NSW RURAL FIRE SERVICE

Your reference: SSD 7387
Our reference: D15/3631

15 August 2016

Camden Medical Campus Precinct – Gledswood Hills

APPENDIX 5: PLANS AND CROSS SECTIONS

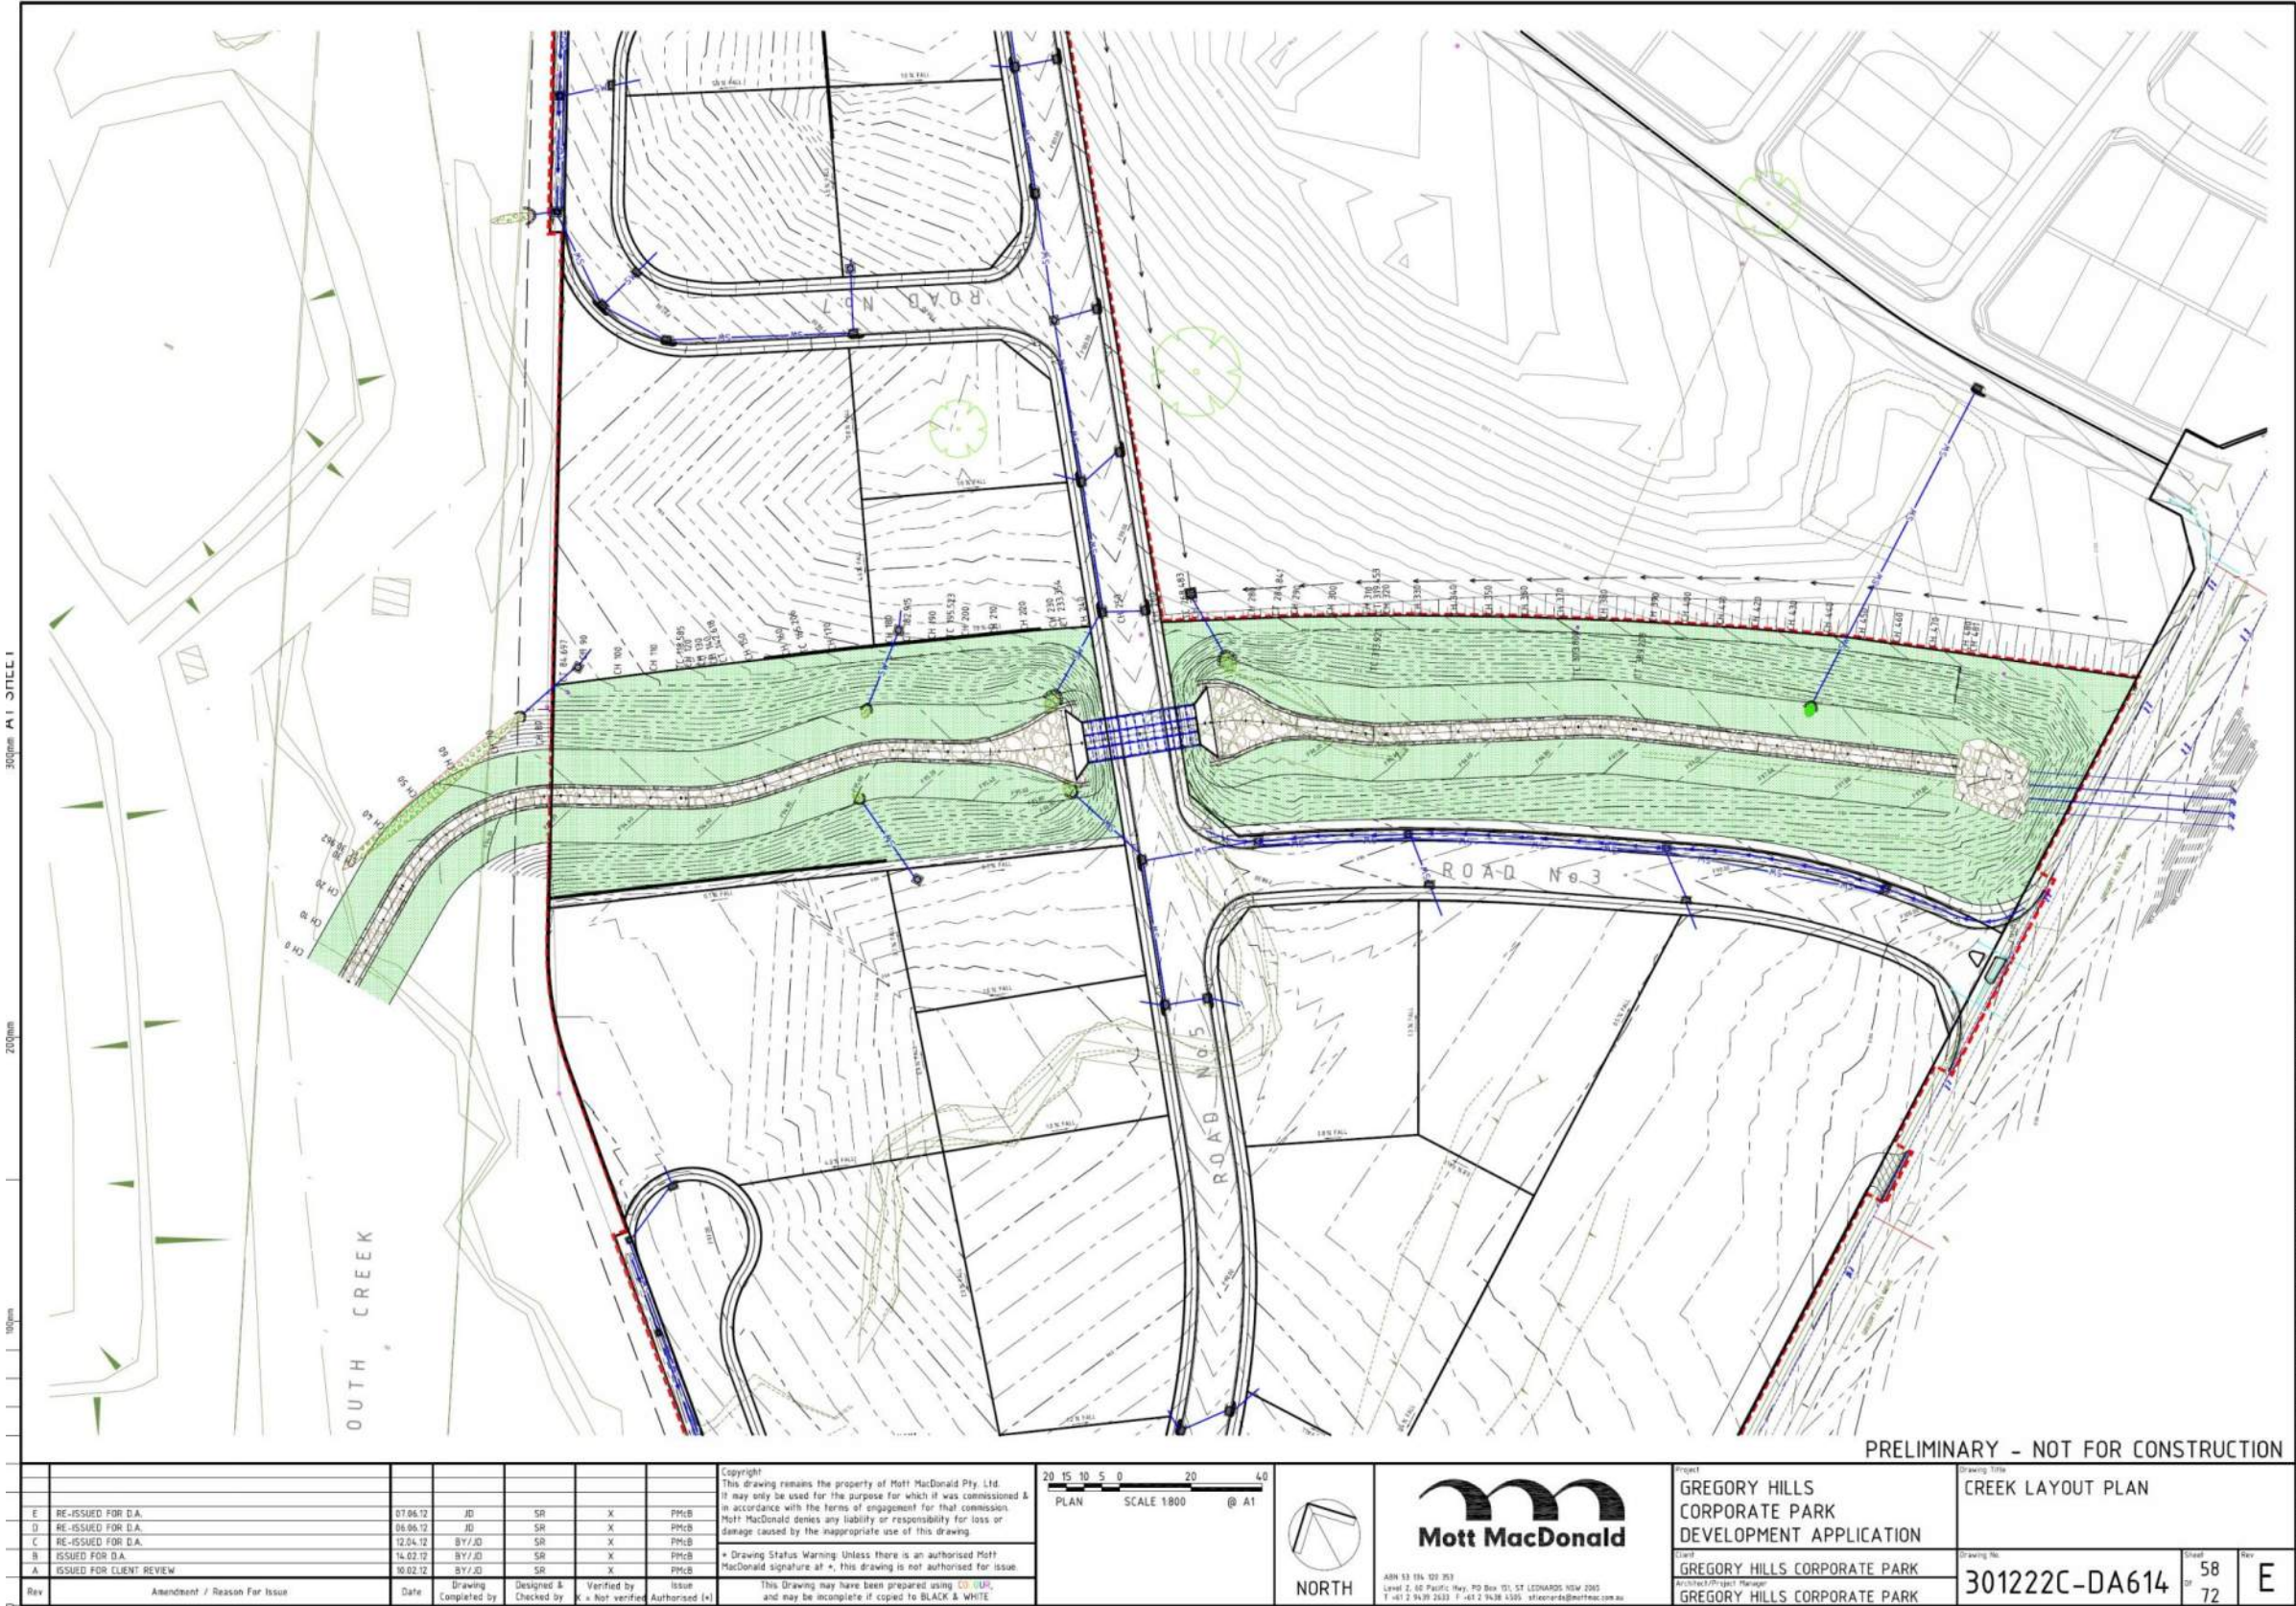
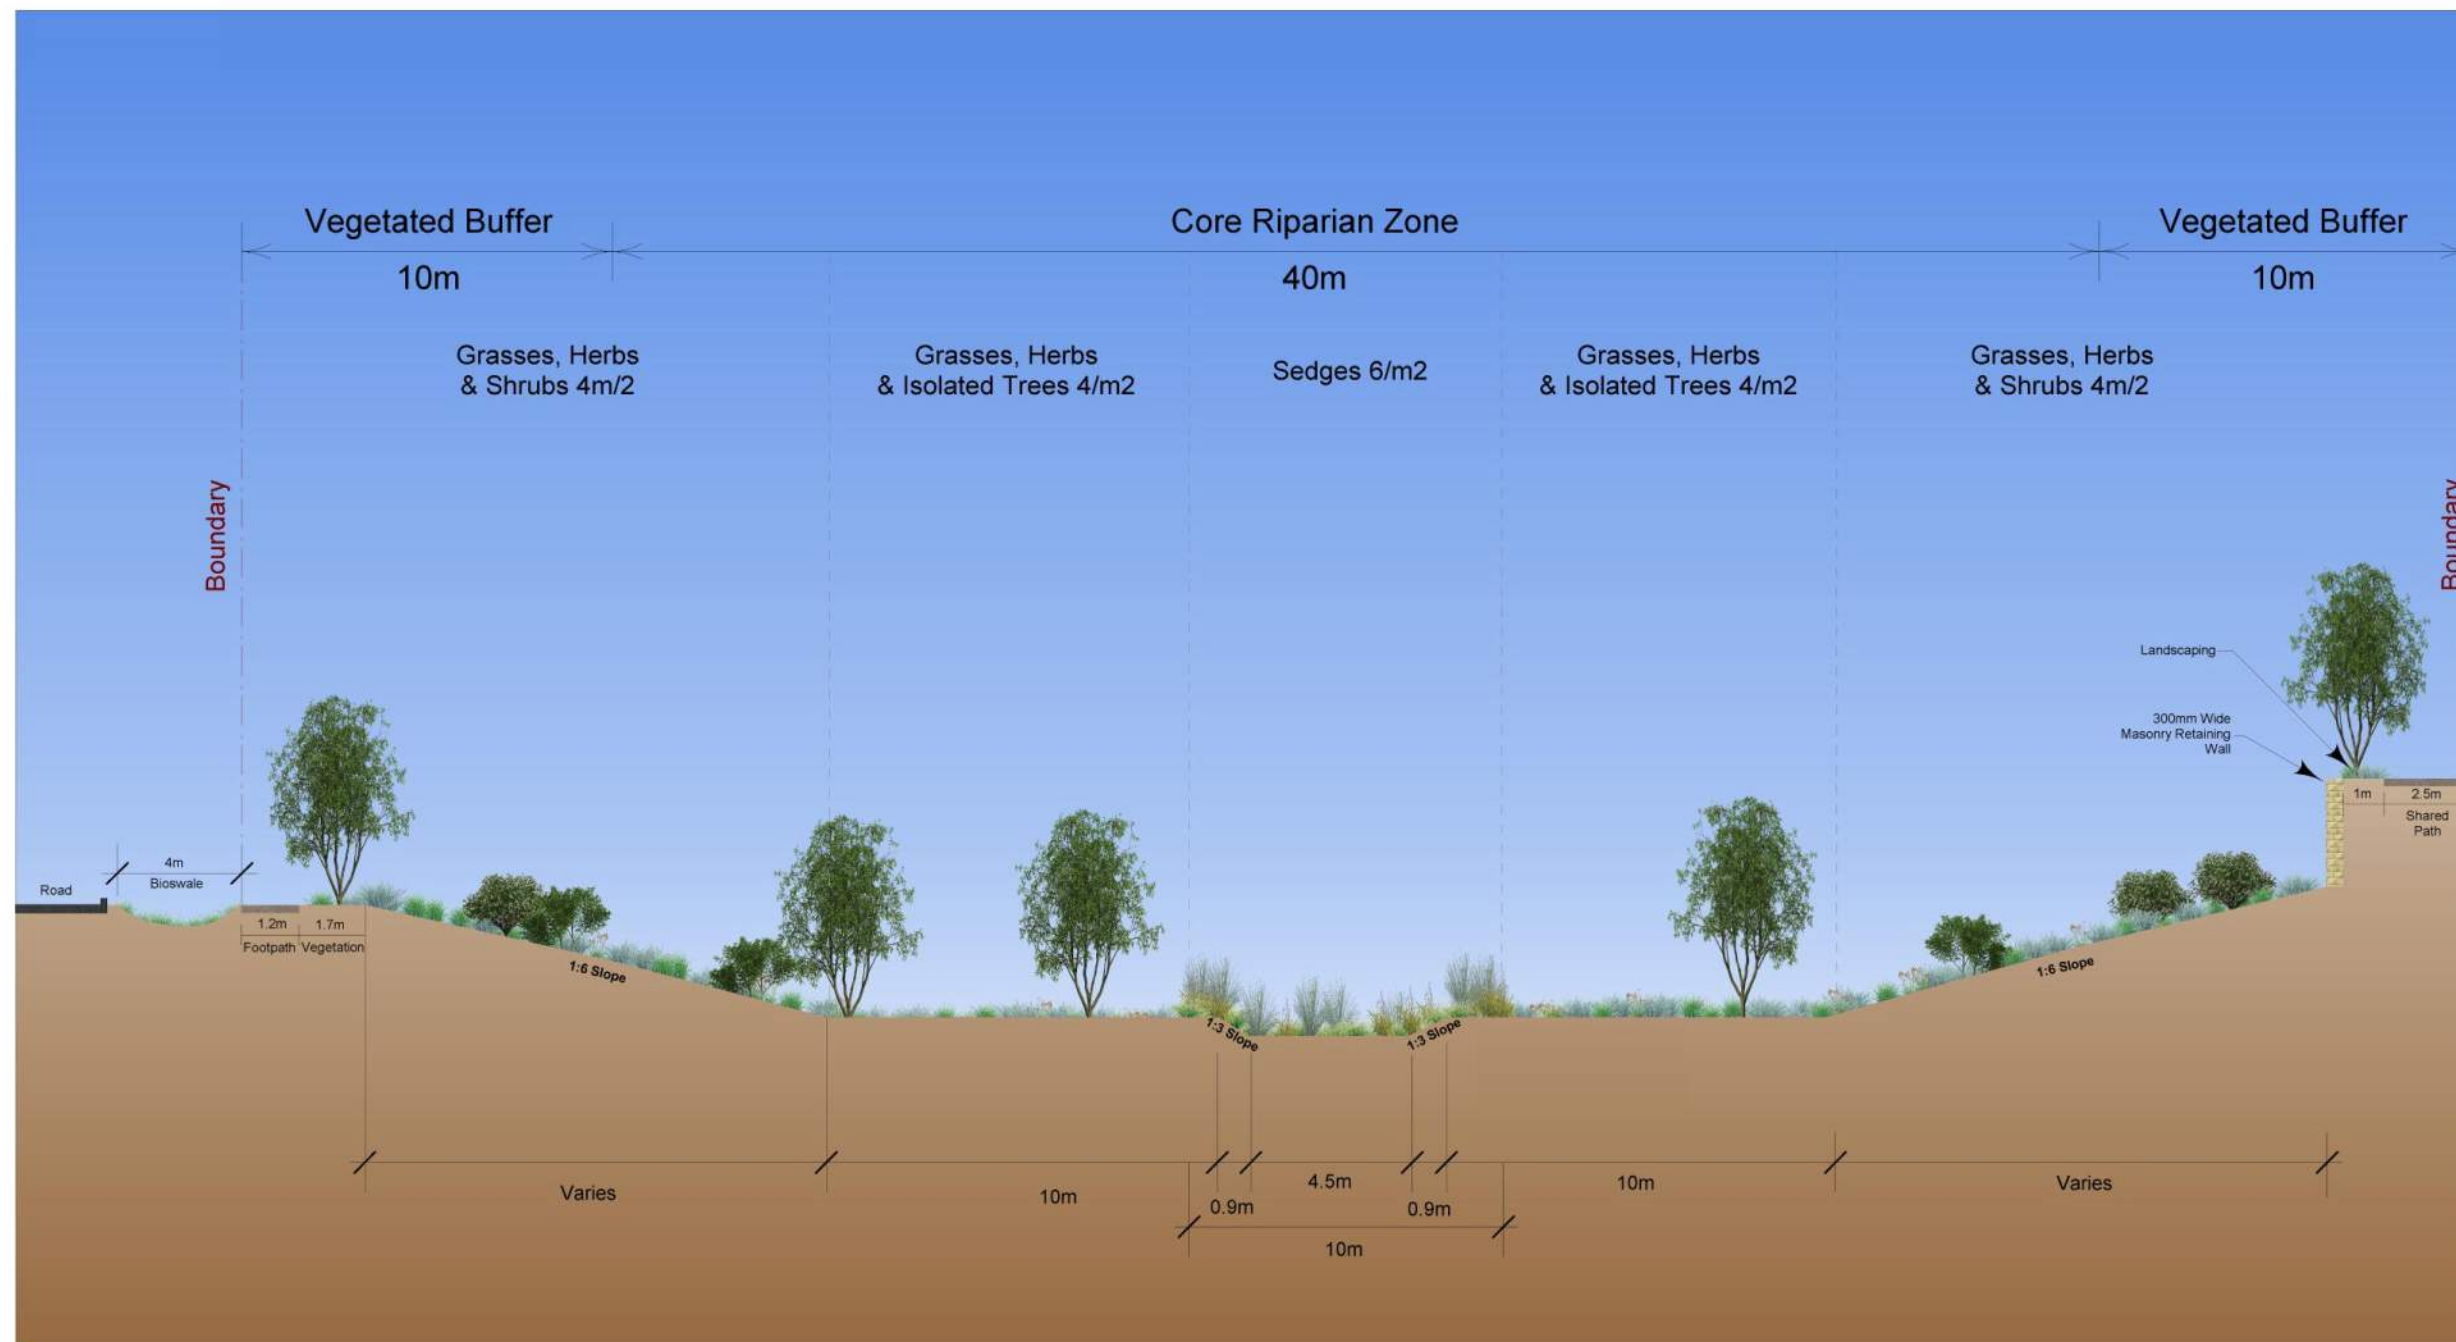
The submitted bush fire advice prepared by Eco Logical Australia Pty Ltd relies on a purportedly endorsed Vegetation Management Plan (VMP) for the adjoining riparian corridor, which entails bush regeneration and weed management for a period of at least five years by the developer. The VMP also states that *additional* maintenance works (as specified in section 3.1.1 of the VMP) will be required in perpetuity in "order to maintain a vegetation community which will not pose a future bush fire hazard", once the land is transferred to Camden Council.

Presuming that *additional* maintenance works can or will be undertaken, it is unclear who will have this responsibility for the maintenance once the land is transferred to Council – the VMP does not provide any clarification on this matter. Furthermore, it is unclear whether the *additional* maintenance works will be sufficient to ensure that the vegetation within the riparian corridor will not pose a future bush fire hazard. The VMP does not clearly specify that the maintenance will be to the standards of an inner protection zone, with particular regards to maintaining a maximum canopy cover of 15% and the removal of shrub species. Furthermore, the initial 5 years of maintenance by the developer may pose a bush fire risk as it does not seem to involve the *additional* maintenance as specified in section 3.1.1 of the VMP.

As such, the NSW RFS does not have sufficient information to properly assess the potential hazards in the adjoining riparian corridor, which may impact the subject development. Further information is required to address the aforementioned matters in accordance with section 3.3(b) of *Planning for Bush Fire Protection 2006*.
